Ribble Valley Borough Council  
Housing & Development Control

Application no: **3/2024/0293**

Address: **Bowland Wild Boar Park Wardsley Road Chipping PR3 2QT**

Proposal: **Approval of details reserved by conditions 4 (construction traffic management plan), 6 (landscaping and maintenance scheme), 8 (Sustainable Drainage Scheme) 9 (drainage maintenance and management plan) and 11 (proposed landscaping) of planning permission 3/2023/0509.**

PDP
 Client: Bowland Wild Boar Park
 Project: Park Extension
 Drawing title: Detailed landscape proposals
 Scale: 1:200 @ A1
 Drawn by: PDP
 Date: March 2024
 Drawing No: C-2217-01

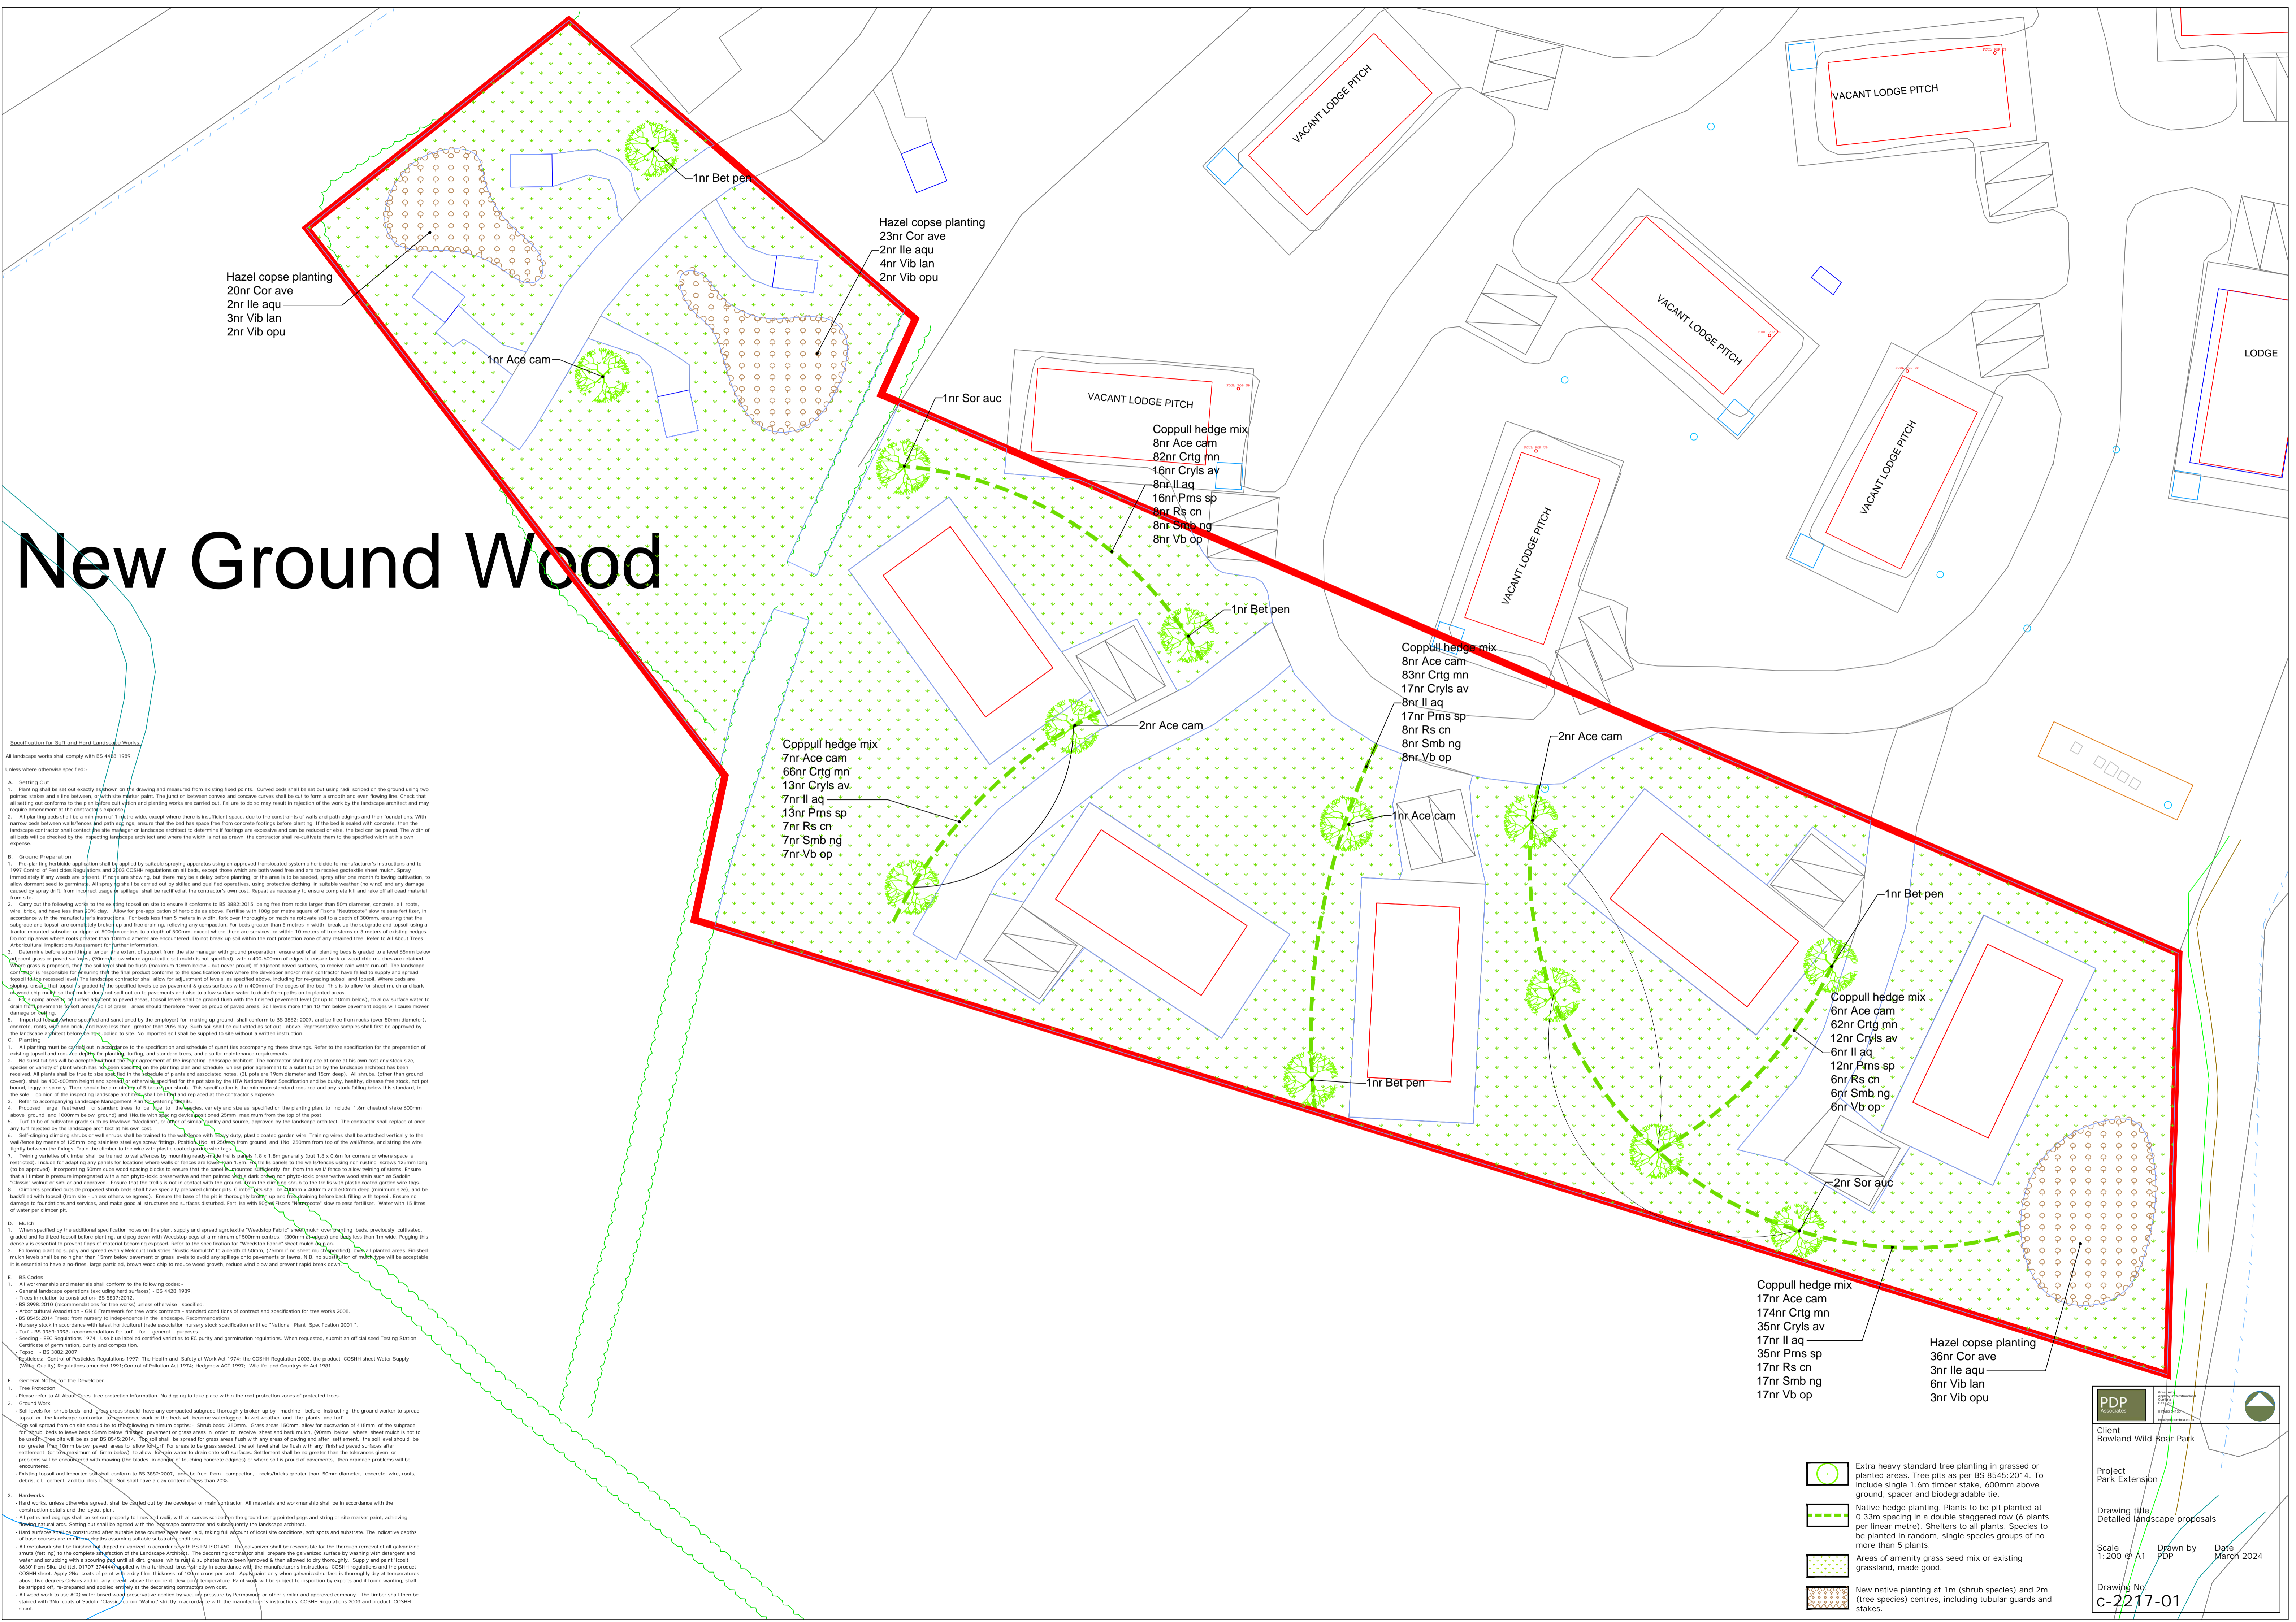
The LHA have reviewed the provided Landscaping Management Plan and require further details to be submitted regarding the maintenance of the vegetation which is located within the site access' visibility splays. The LHA require these details to ensure that nothing higher than 1m will be allowed to grow or erected within the access' visibility splays for the lifespan of the development.
